Date: 12 January 2026

Application by Beacon Fen Energy Park Limited for an Order granting Development Consent for the Beacon Fen Energy Park Project

This letter sets out Lincolnshire County Council’s (LCC) comments on the additional information and submissions received at Deadline 5.

Soil Stockpile Design

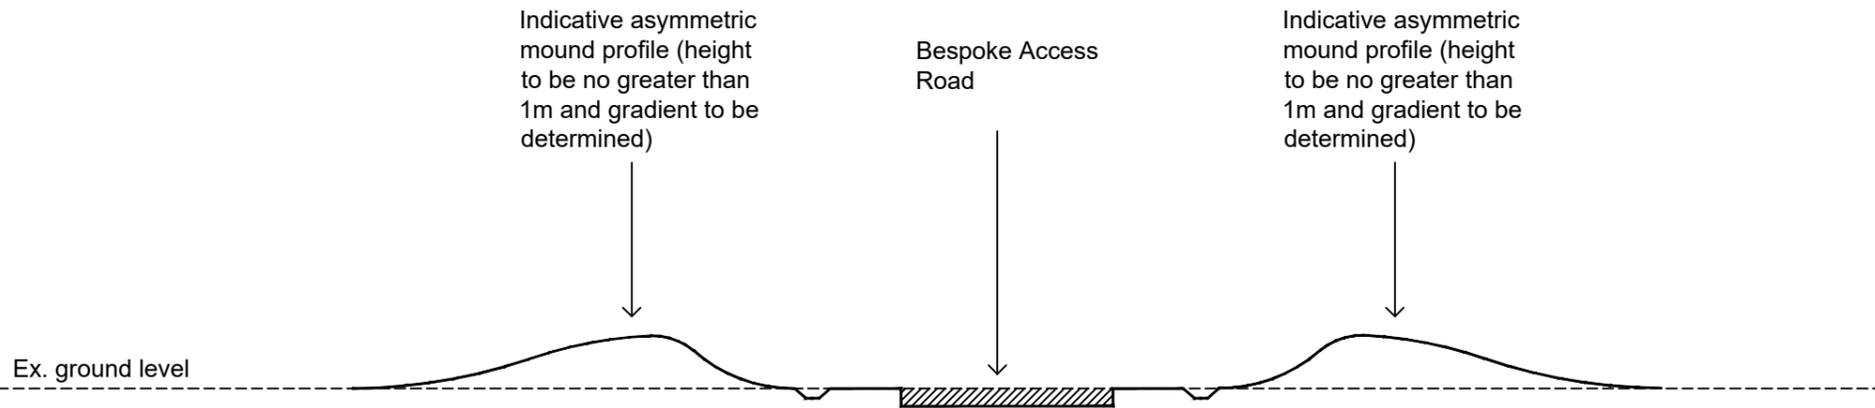
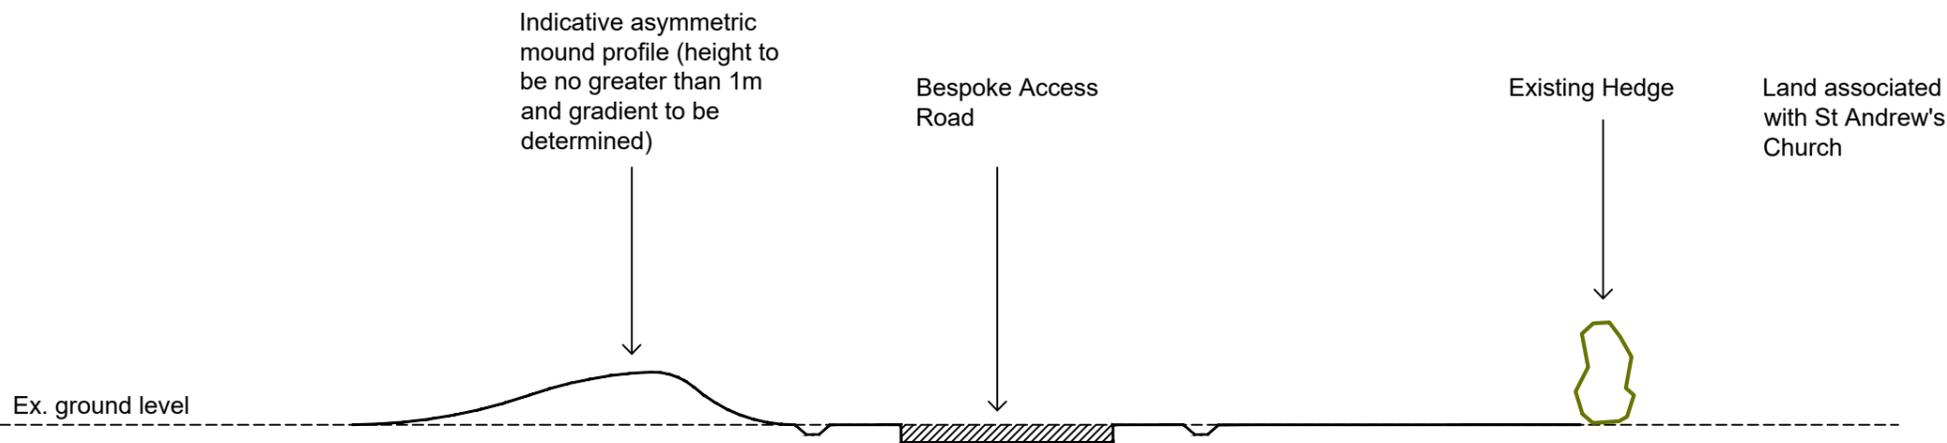
Paragraph 6.3.20 of the updated LVIA identifies Stockpiles at 0.5 to 1.0m in height adjacent to the bespoke access road. There are two concerns in regards to these features:

1. The bunding would be out of character in this landscape and would likely appear as an engineered feature. This is a relatively flat, open landscape, and bunding such as that proposed would potentially be conspicuous in views and out of character with the existing landscape. We do however acknowledge that these are currently proposed as relatively low features, lessening their presence in views. Paragraph 6.6.57 of the LVIA has been updated to consider these new features, however we disagree that these elements will harmonise with the immediate context of the agricultural landscape as they will likely appear as engineered elements out of character with the existing landscape character and in themselves have the potential to have adverse landscape and visual effects; and

2. A topsoil stockpile for use decades later is not likely to be effective. We would welcome clarification from the applicant in this regard and a maintenance process that would maintain the topsoil integrity, but topsoil stockpiles are typically in place for a relatively short amount of time, usually 6 to 36 months. The characteristics of the soil are likely to change over a protracted period of time when in a stockpile, and in our experience unlikely to be useable.
